(Development Charges Letter)

File No. : CMDA/PP/NHRB/S/1078/2019

Sub: CMDA-Area plans Unit - 'B' Channel (South) – The Planning Permission application received for the proposed construction of Stilt floor + 5 Floors with 8 dwelling units availing Premium FSI of Residential Building at Plot No.7A, D.No.8/16, Srinivasa Avenue Road, Raja Annamalaipuram, Chennai -28. Comprised in Old S.No.4253/2 (Part) as per document and New R.S.No.4253/10 and 75, as per patta Block No.91 of Mylapore Village within the limit of Greater Chennai Corporation- Remittance of DC & Other charges – DC advice Sent - Reg

TYPICAL FLOOR PLAN (2nd, 3rd & 4th FLOORS)

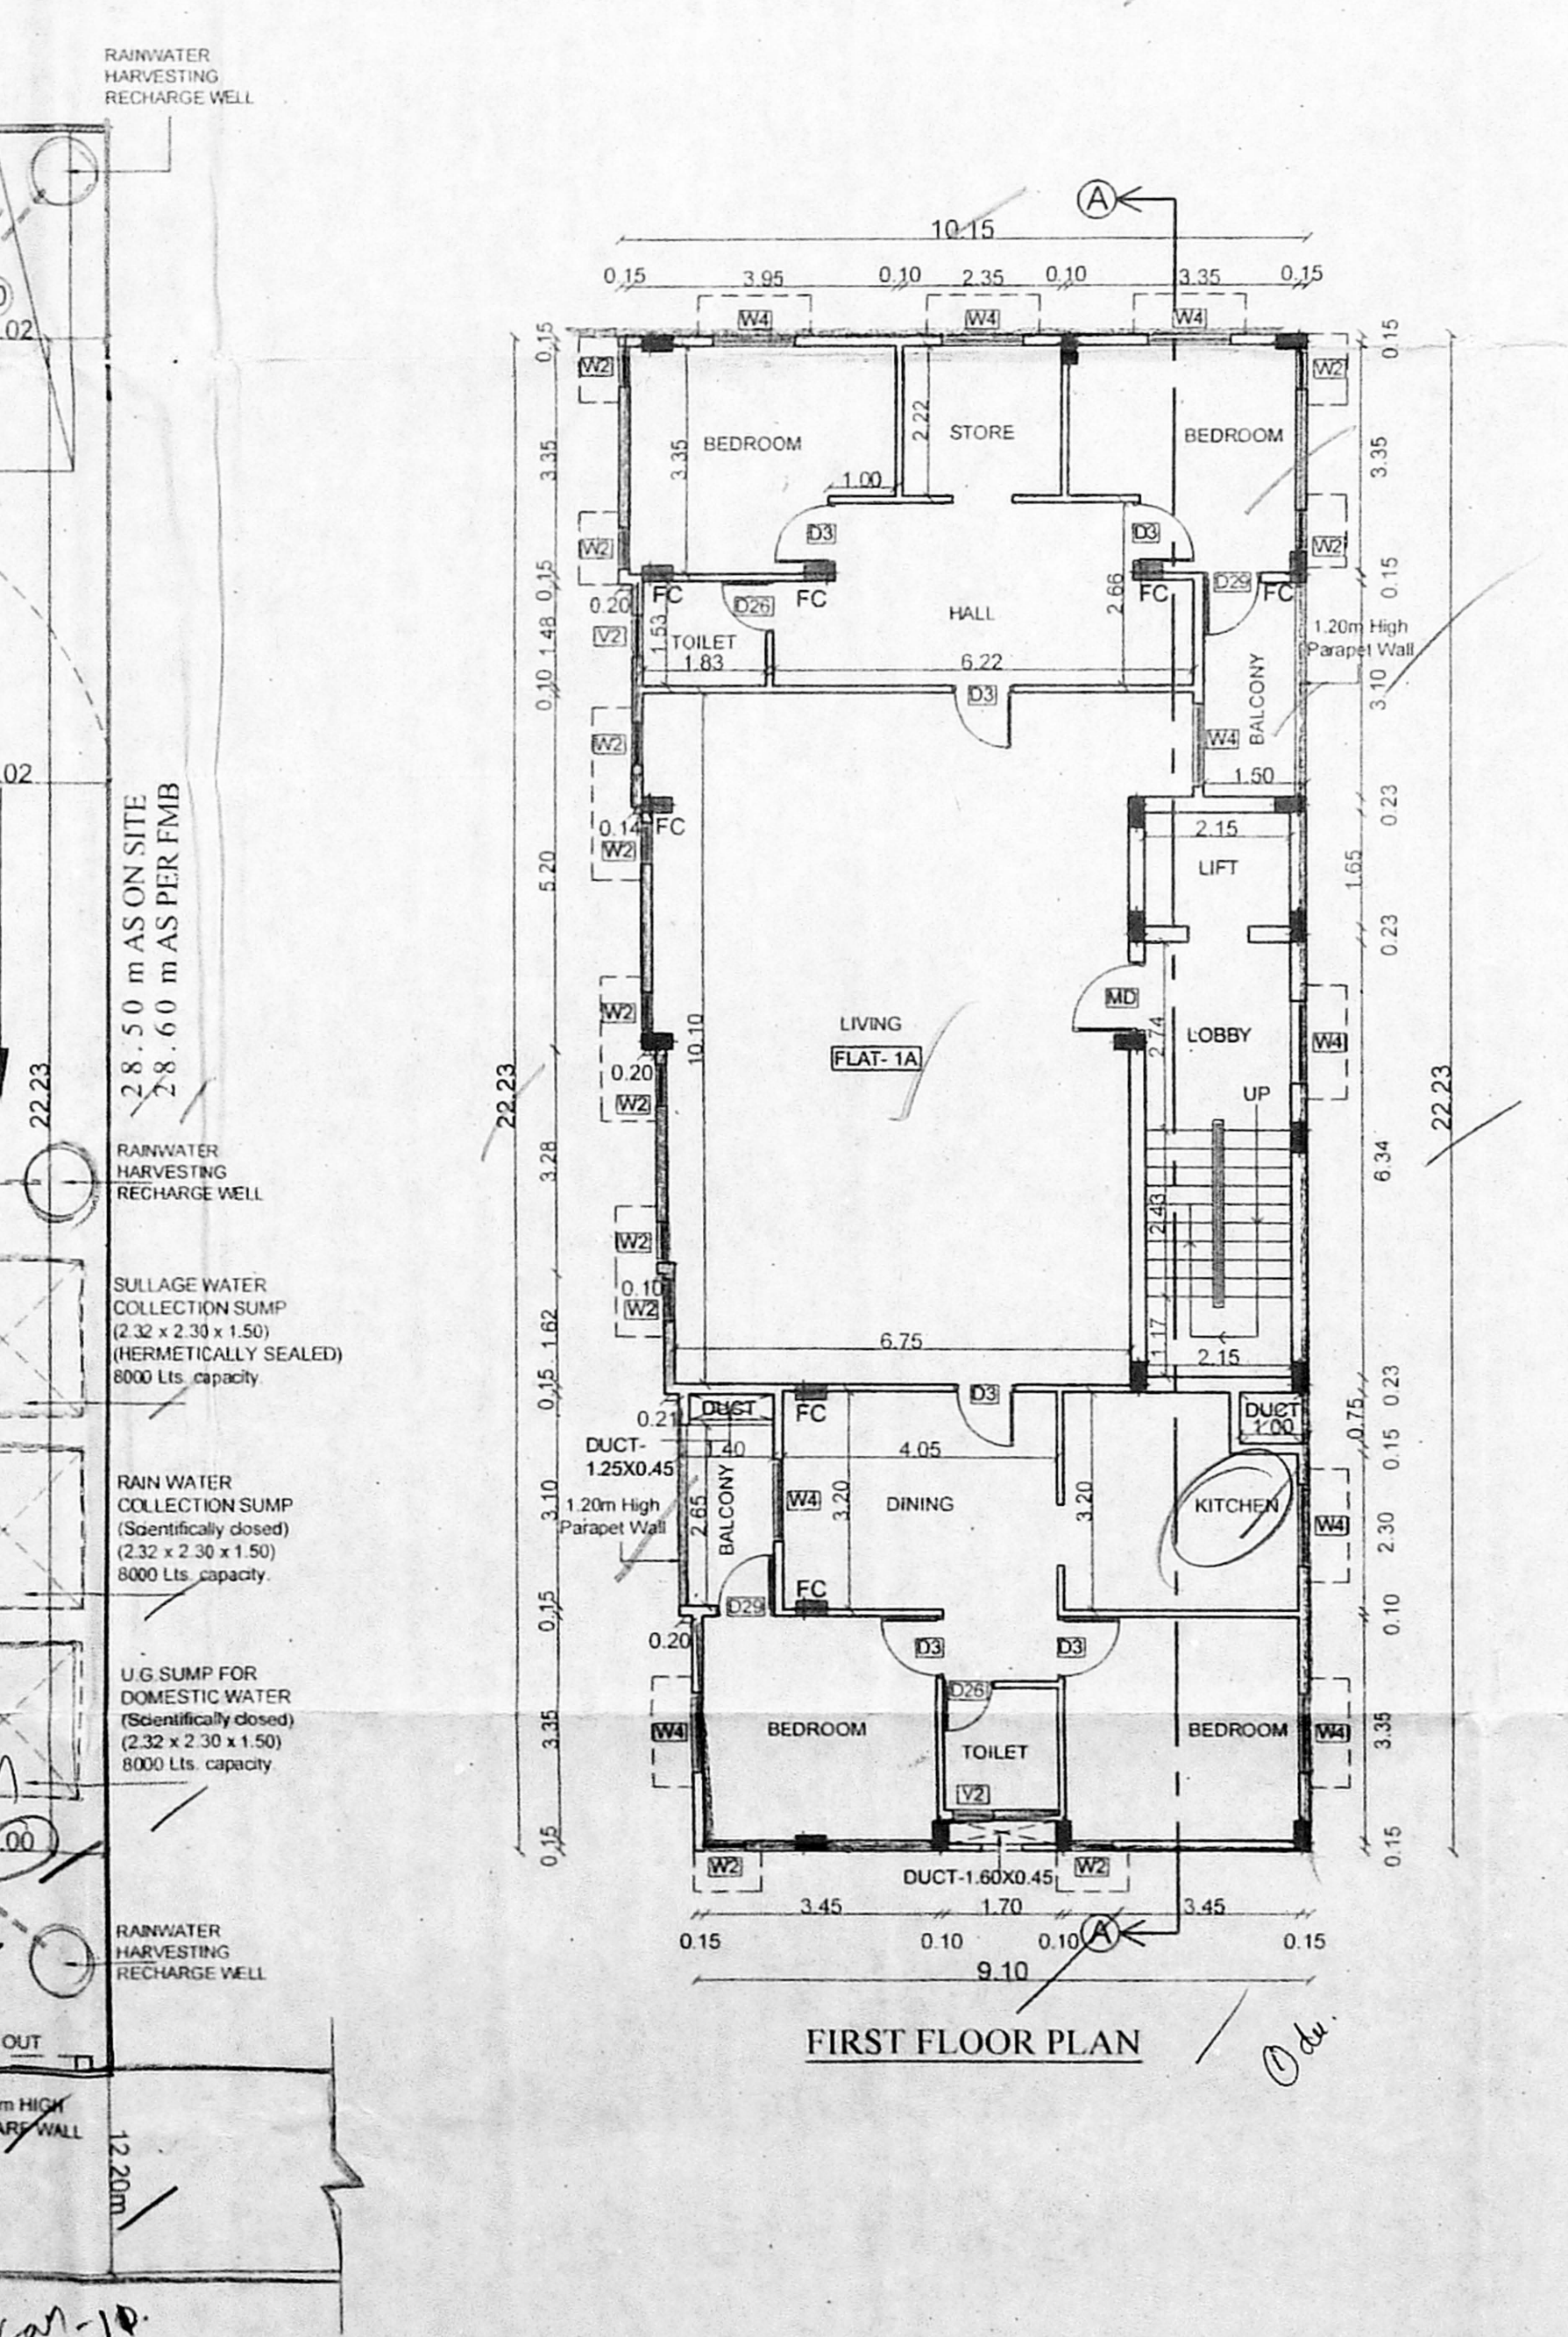
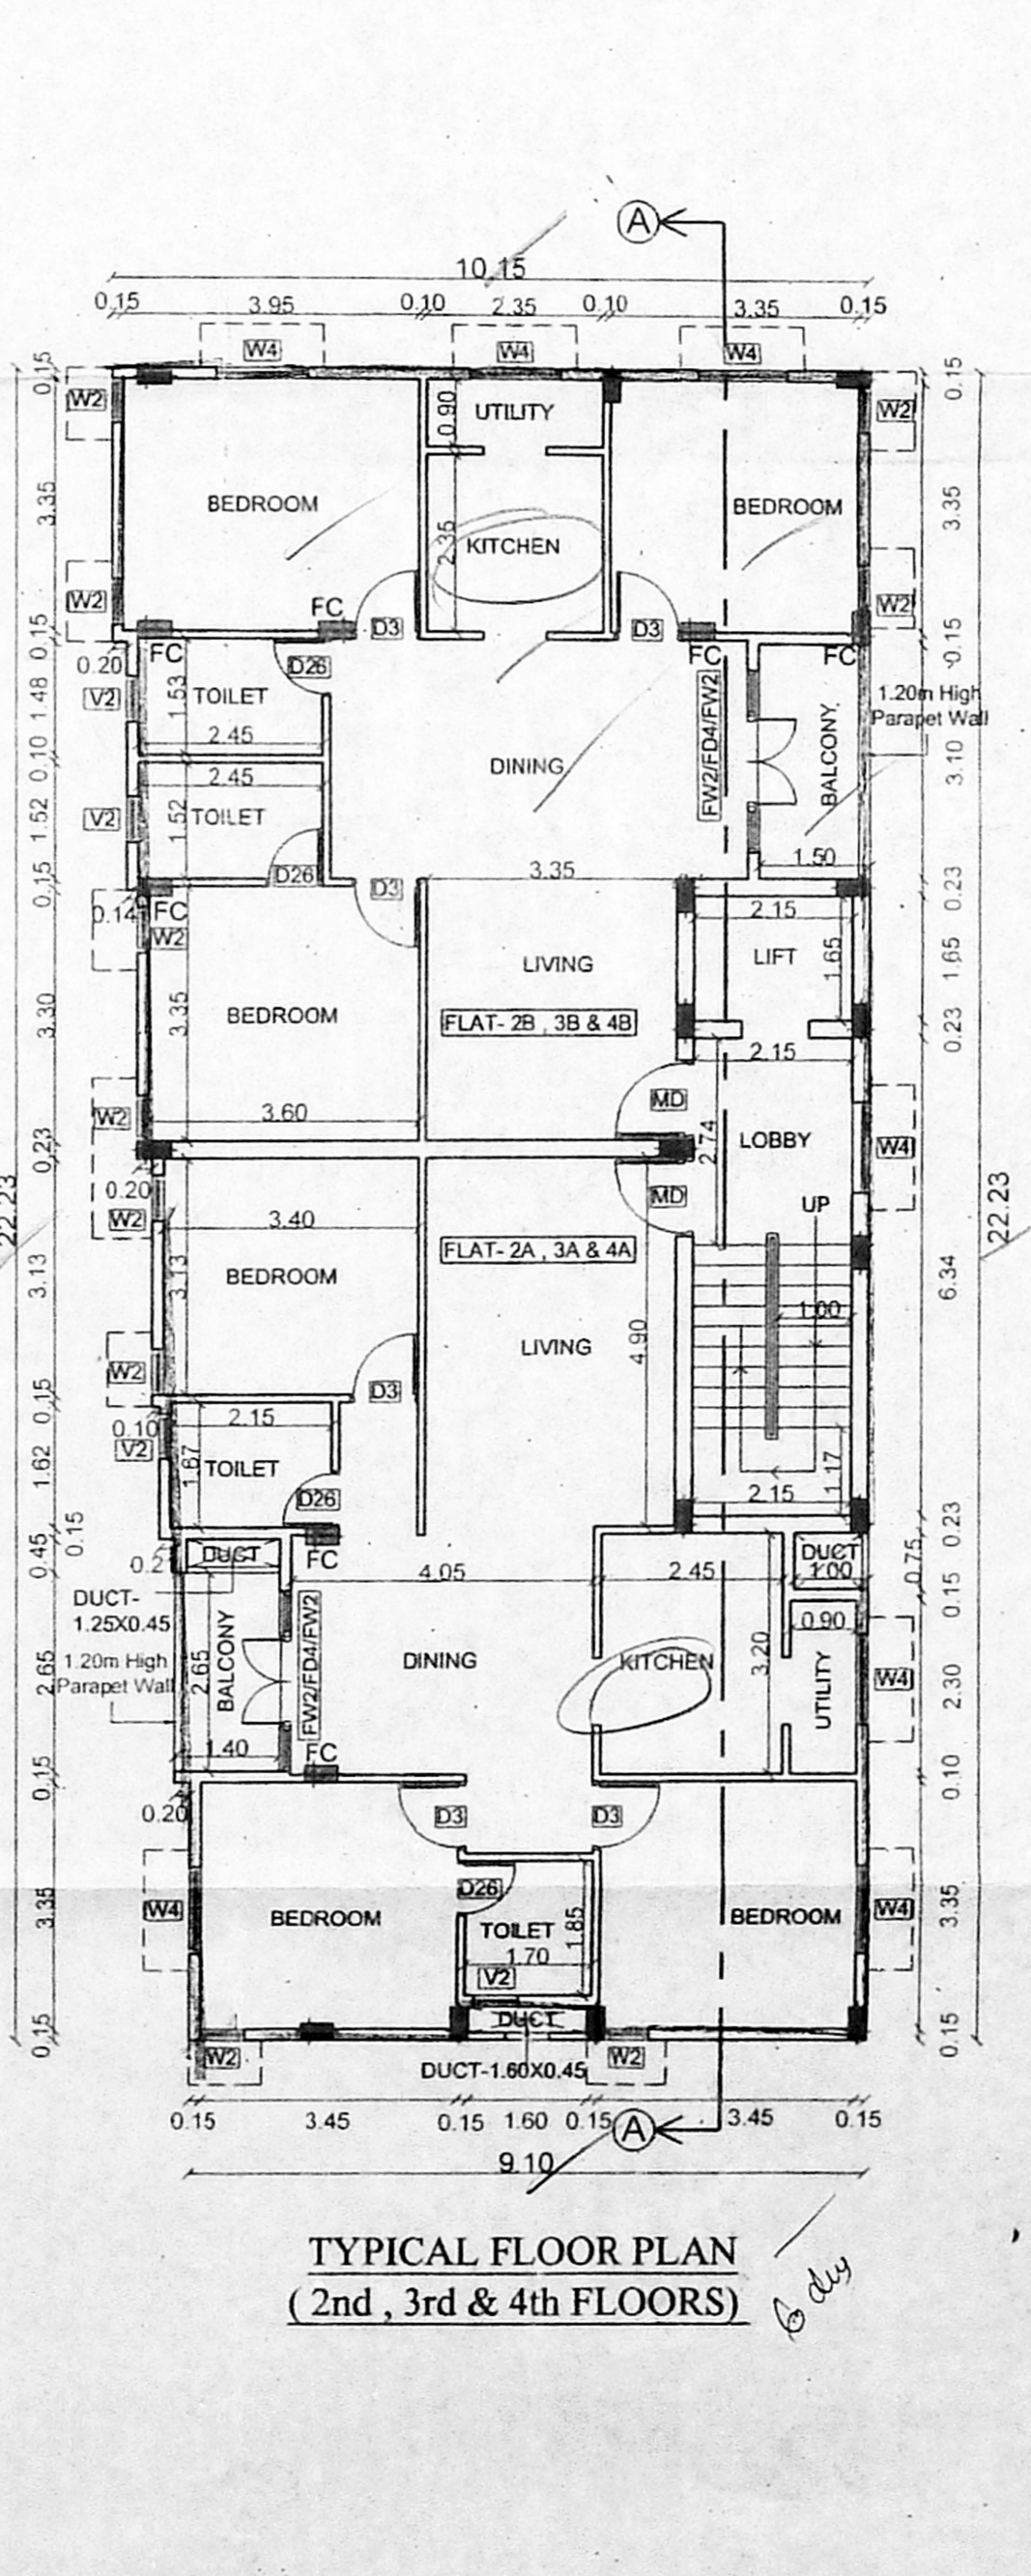
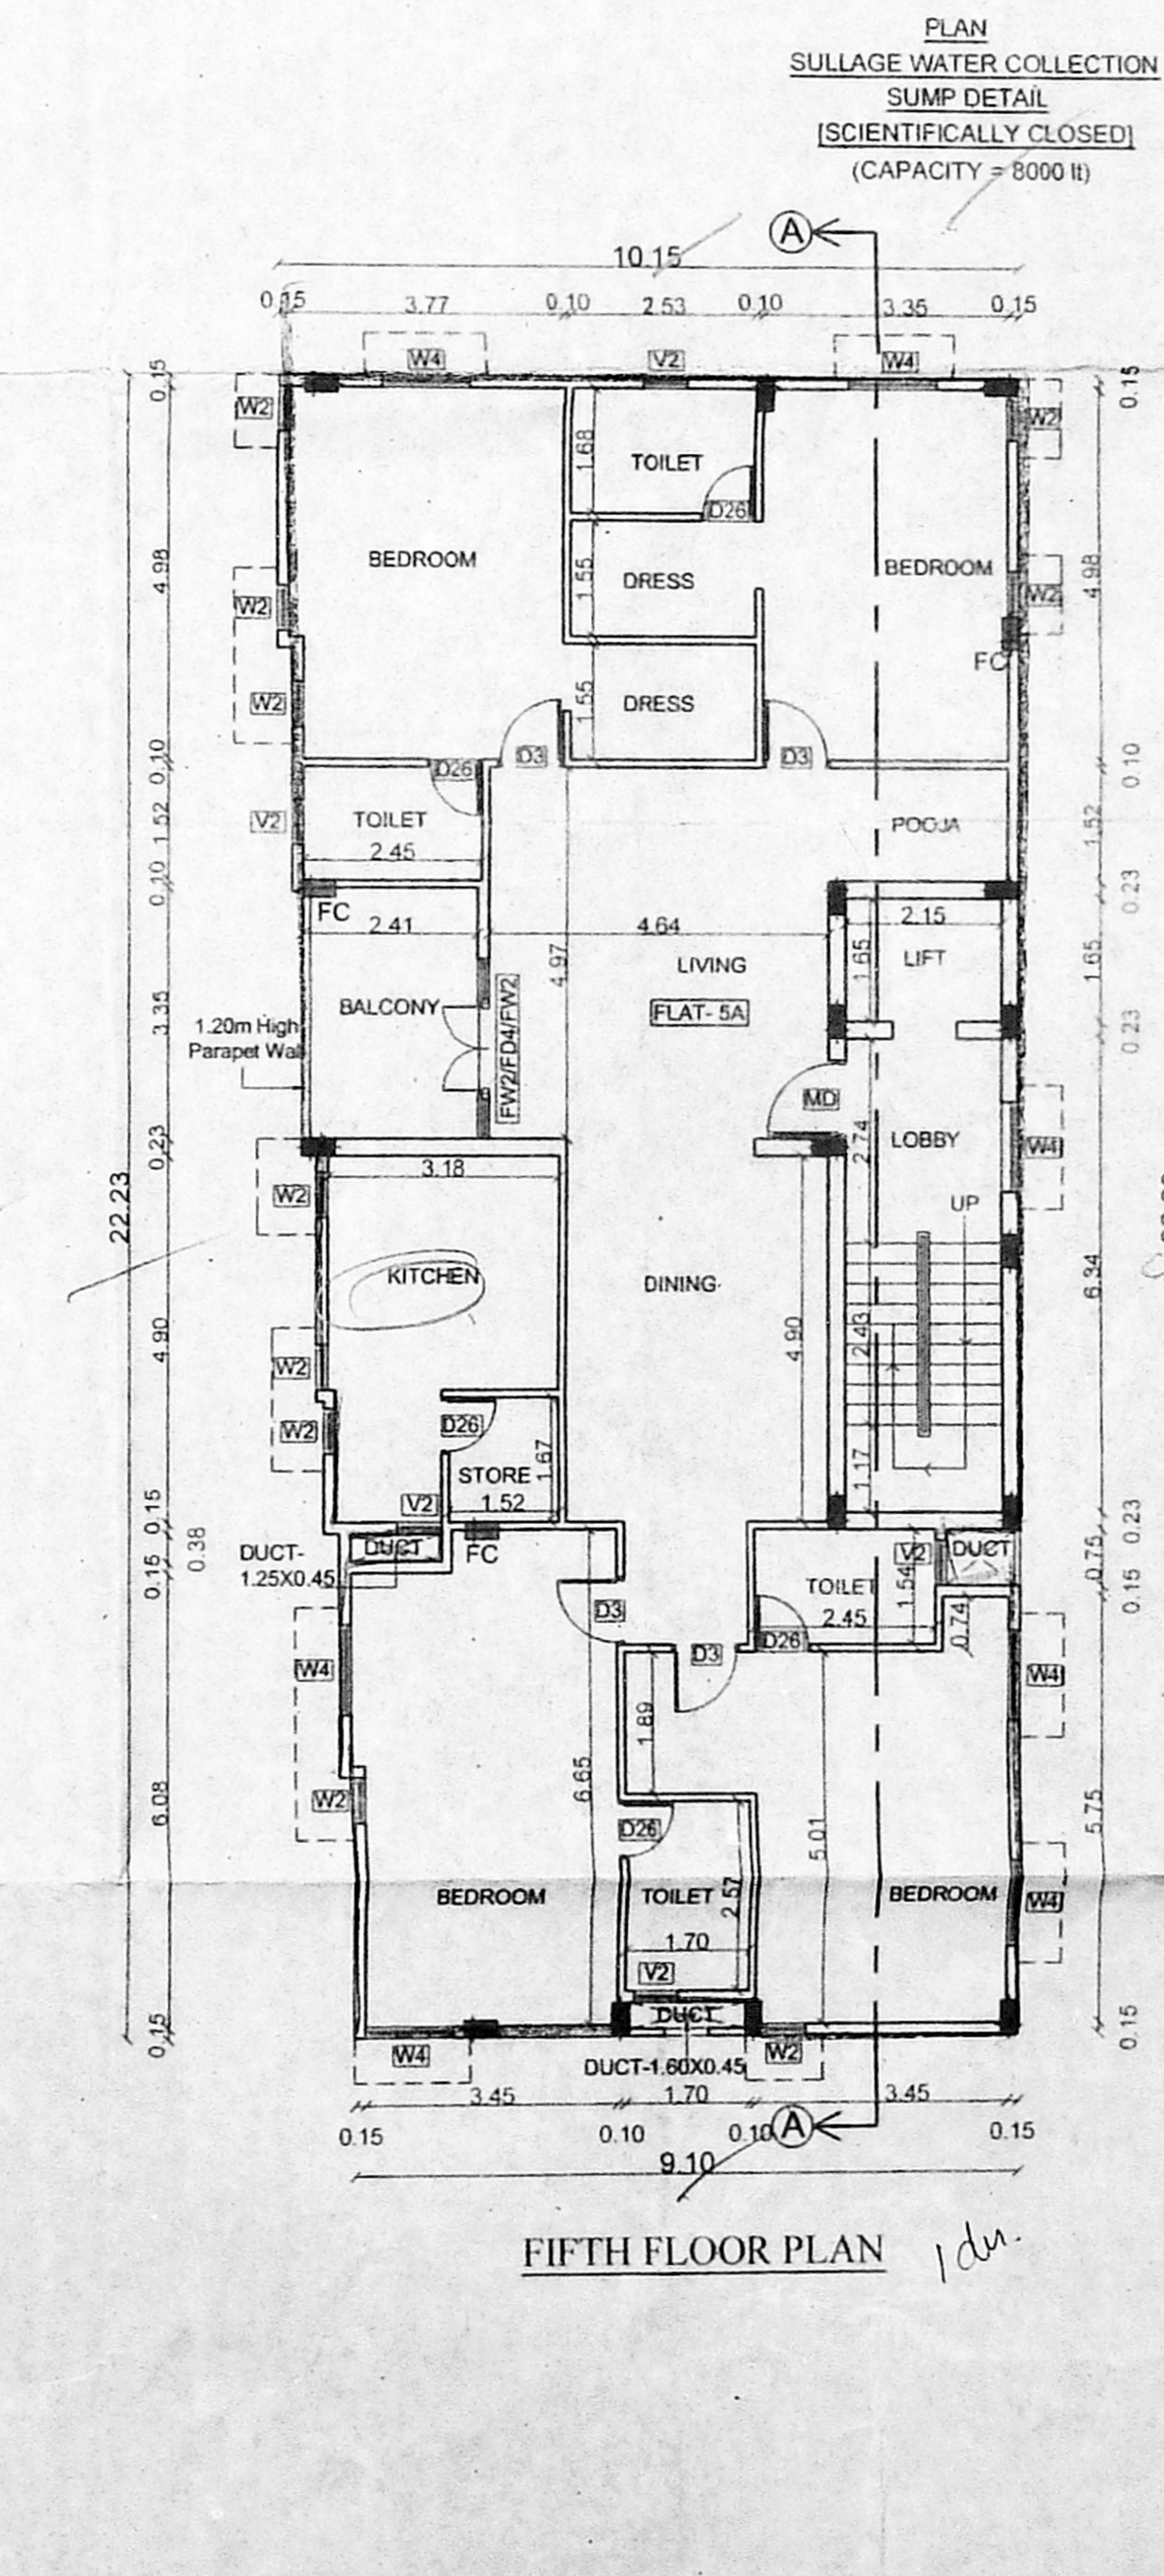
- Handrail to be shown in balcony of all floor plan.
- Drive way ,turning radius ,aisle width and in the electrical transformer room rolling shutter and 2no of exhaust fan to be provided as per TNCD&BR.in the site plan.
